Rezoning Transportation Analysis

Petition Number: 2019-156

Date	Description
12-19-2019	First Review
02-18-2020	Second Review (WB)

**REZONING PLAN 2019-156**

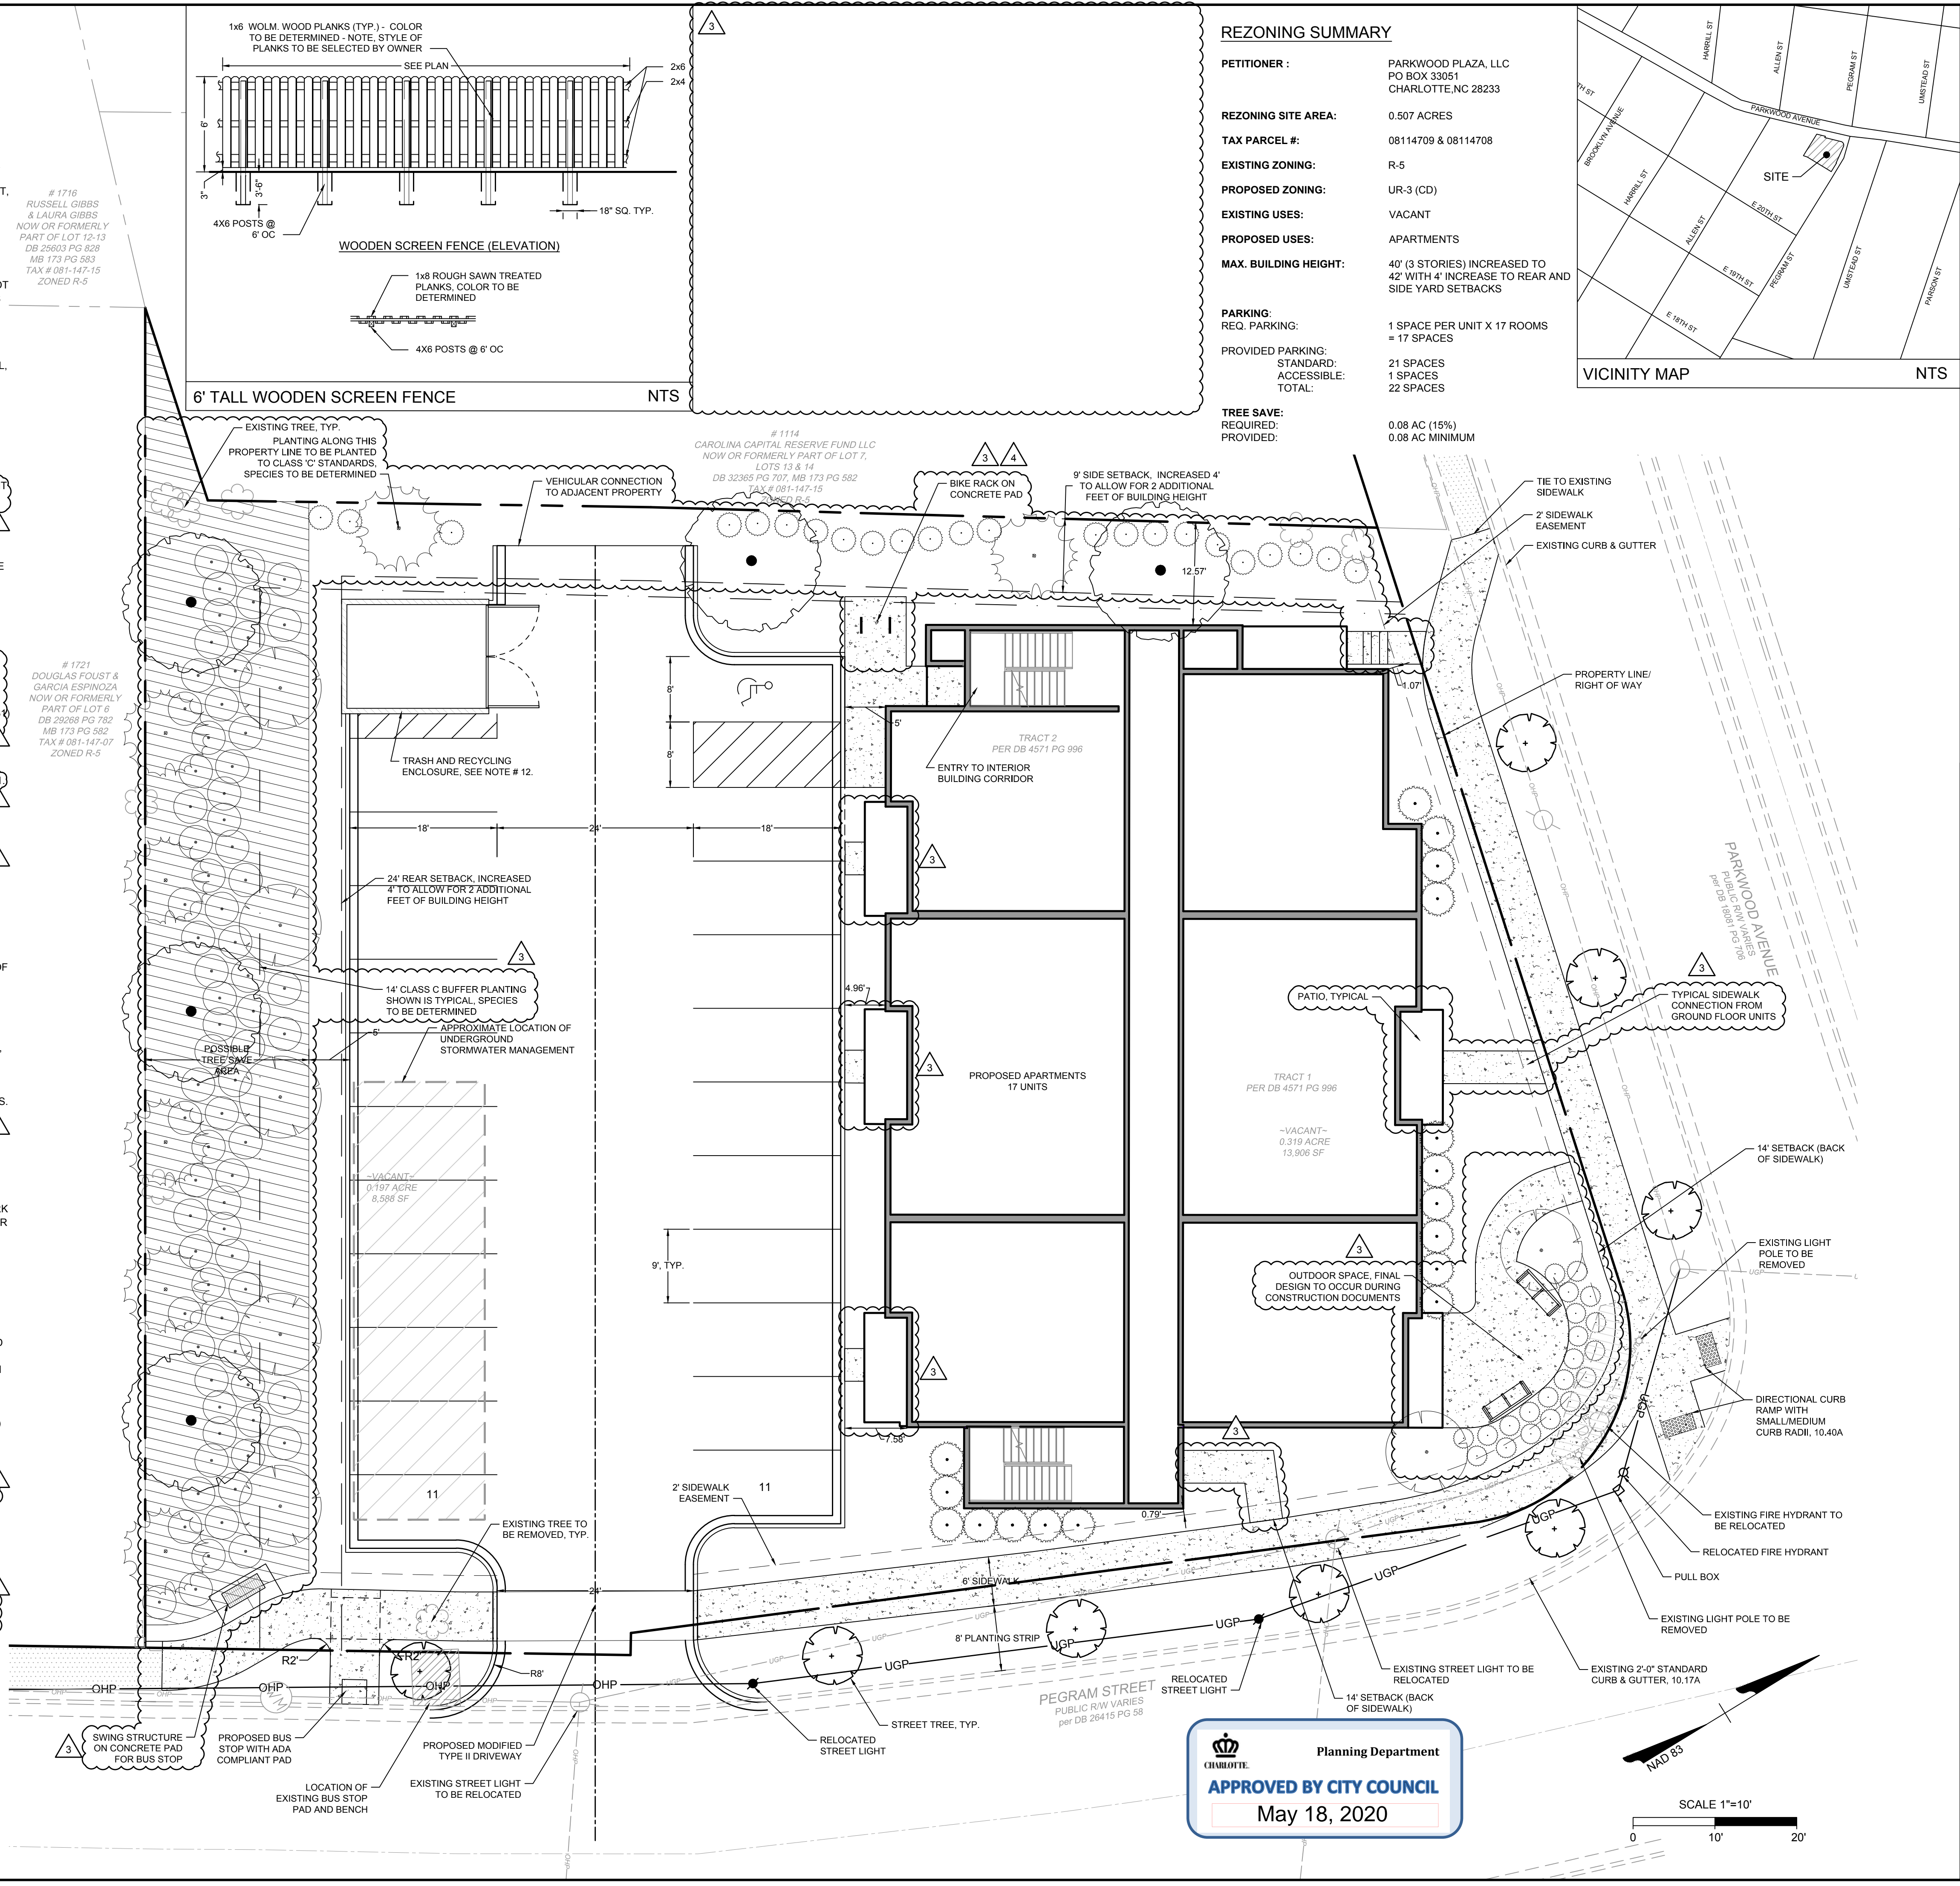
The site is located on a major thoroughfare. The petitioner committed to providing an 8-foot planting strip and a 6-foot sidewalk on Pegram Street and Parkwood Avenue. The petitioner should add a conditional note stating that they will construct two ramps at the corner of Pegram Street and Parkwood Avenue.

- ~~**Traffic Study**~~ A Traffic Impact Study is not necessary for the complete review of this petition.
- The petitioner should revise the site plan and conditional note(s) to commit to construct two directional ramps at the intersection of Parkwood Avenue and Pegram Street, per the *Parkwood (N. Davidson - The Plaza) Improvements* construction plans. Please refer to these plans within the rezoning site plan and conditional note(s). The Parkwood (N. Davidson – The Plaza) plans are available upon request.

4. The petitioner should revise the site plan and conditional note(s) to remove the truncated domes and to continue the sidewalk at-grade across the driveway.

5. The petitioner should revise the site plan to add a note specifying dedication and fee simple conveyance of all rights of way to the City before the site's first building certificate of occupancy is issued. CDOT requests right of way set at 2 feet behind the back of sidewalk where feasible.

- The petitioner should revise the site plan and conditional note(s) to include utility easements where underground conduit is placed outside of the public r/w for the relocated street lights. The petitioner should commit to upgrading the street lighting along the site's right-of-way frontage to LED. Coordinate with Patrick Monroe (Patrick.Monroe@ci.charlotte.nc.us at 704-336-3937).

- The petitioner should revise the site plan and conditional note(s) to clearly define the on-site ordinance required bicycle parking.
